FP/97/26/HH. 18 Ashmere Lane, Felpham, PO227QT.

In response to your letter, please find attached drawing 1245.03.REV A, showing dimensions from the proposed extension to the site boundary as requested.

Drawing: Proposed Elevations.	
For: Penny & Jerry Spurr.	
Drawing Number: 1245.02.PI.	Revision: -
Scale: 1:50 @ A1.	Date: July 2026.

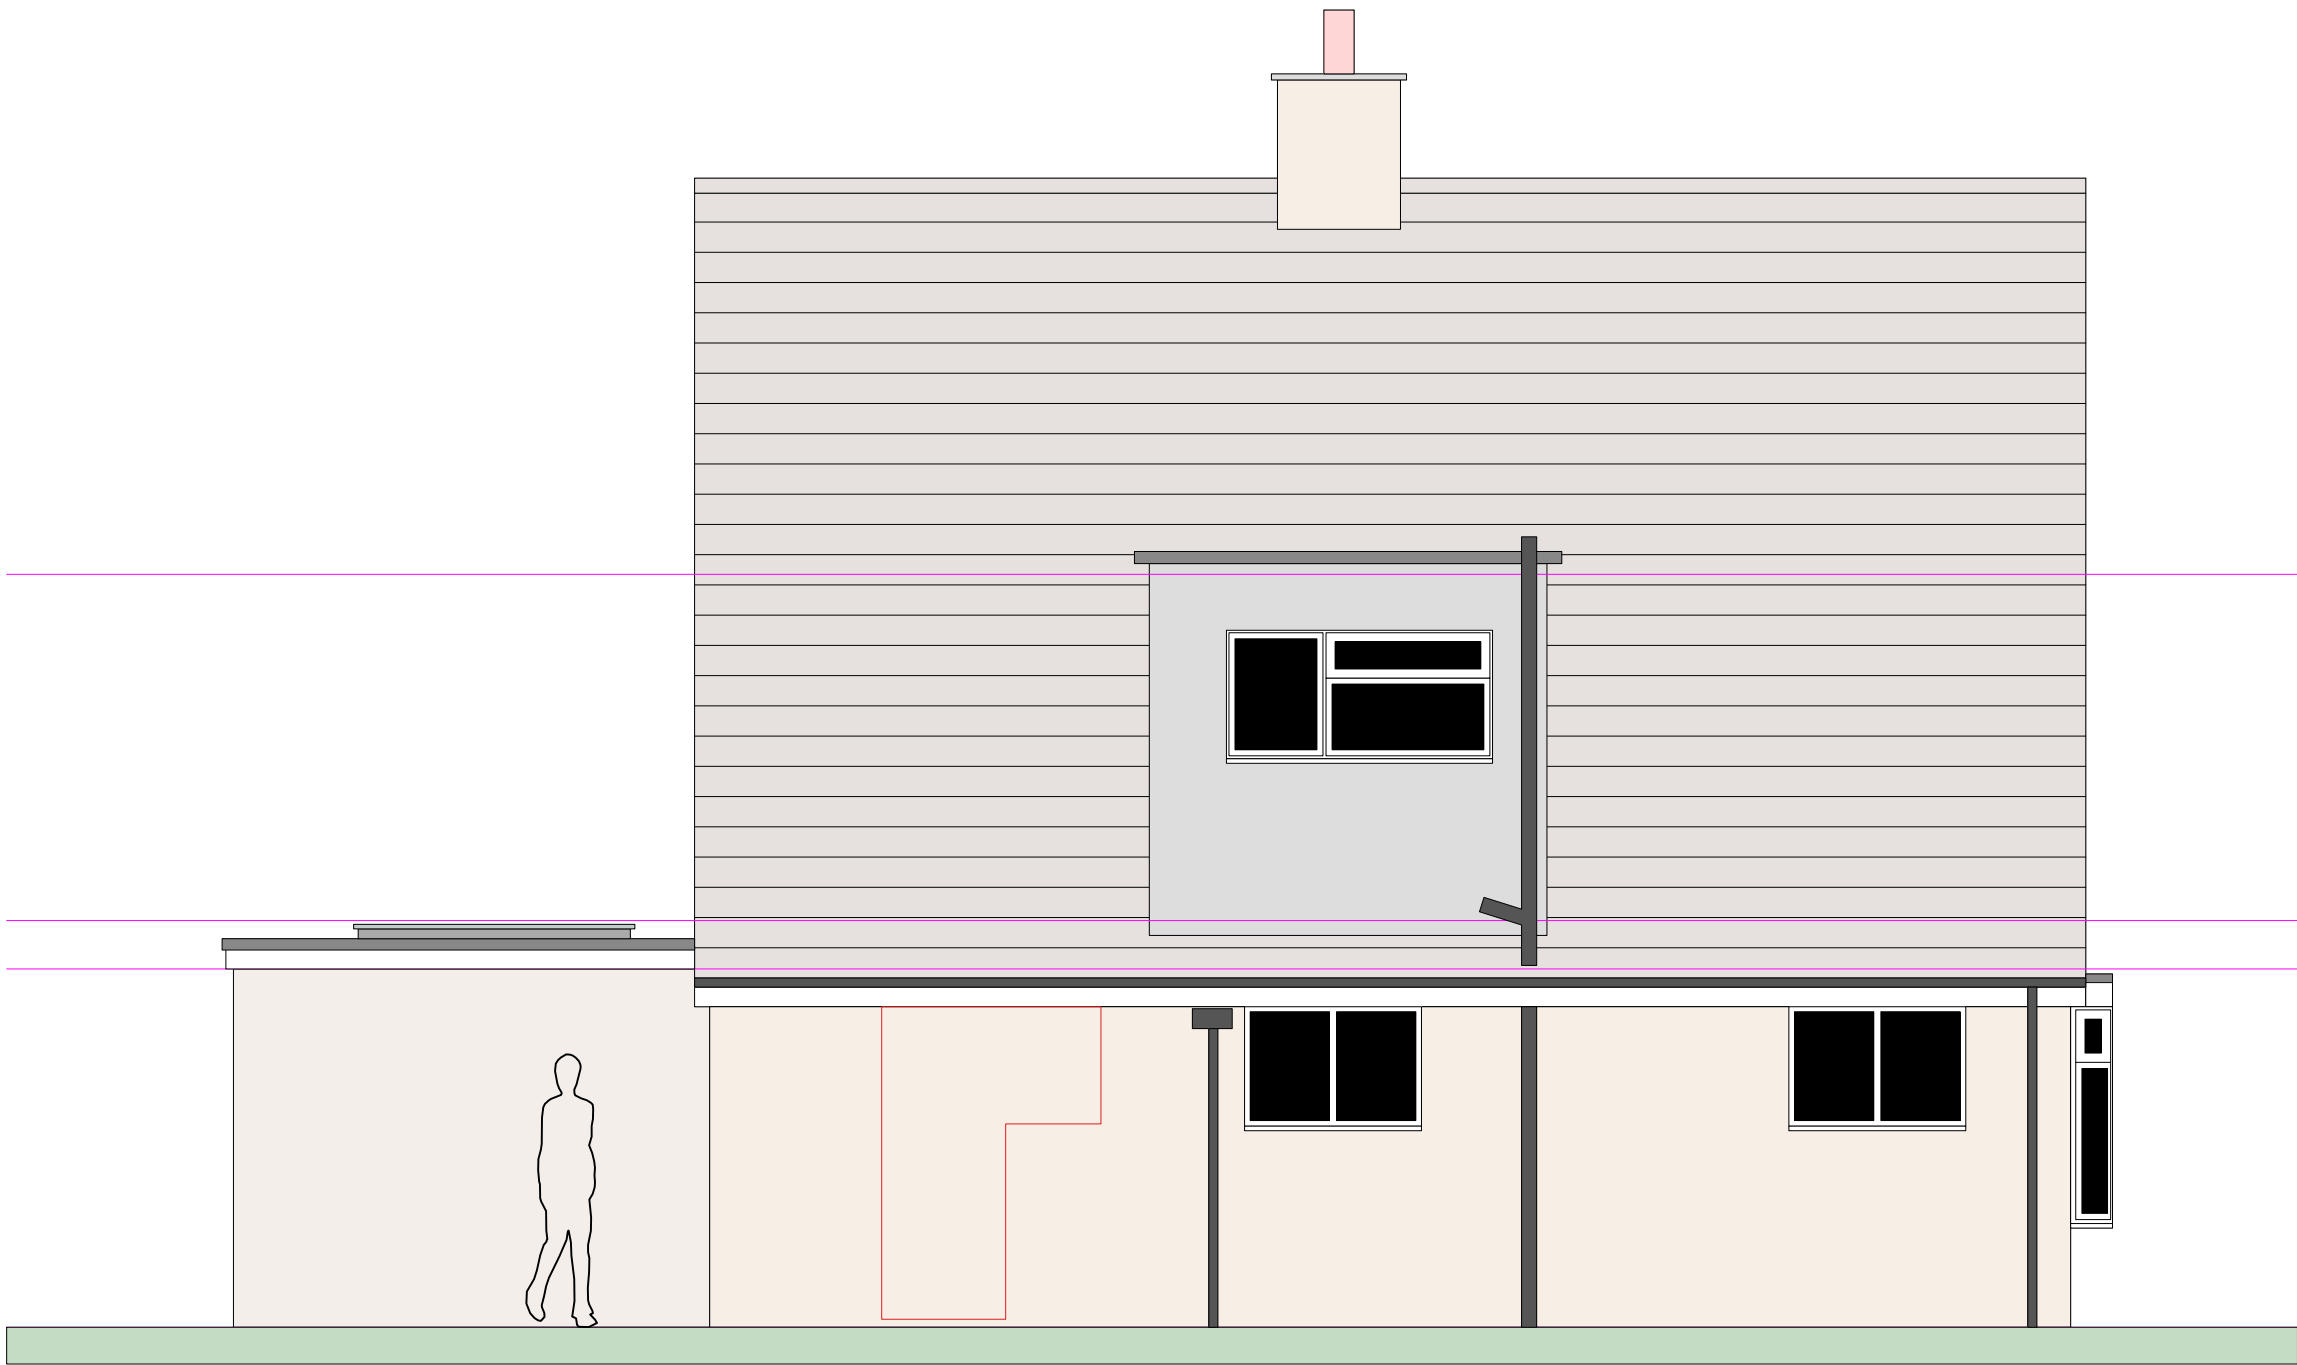
As clarified, the existing south elevation window at ground floor level and north elevation window at first floor level are, as you state existing. They do not need to be more clearly drawn. The existing ground floor window is within a cavity wall and is consistent in detail with all other existing windows at ground floor level. The existing window at first floor level is set within a timber framed dormer. My surveyor did not draw a line in the middle of the window as you state, but it is clear without question that this is a window.
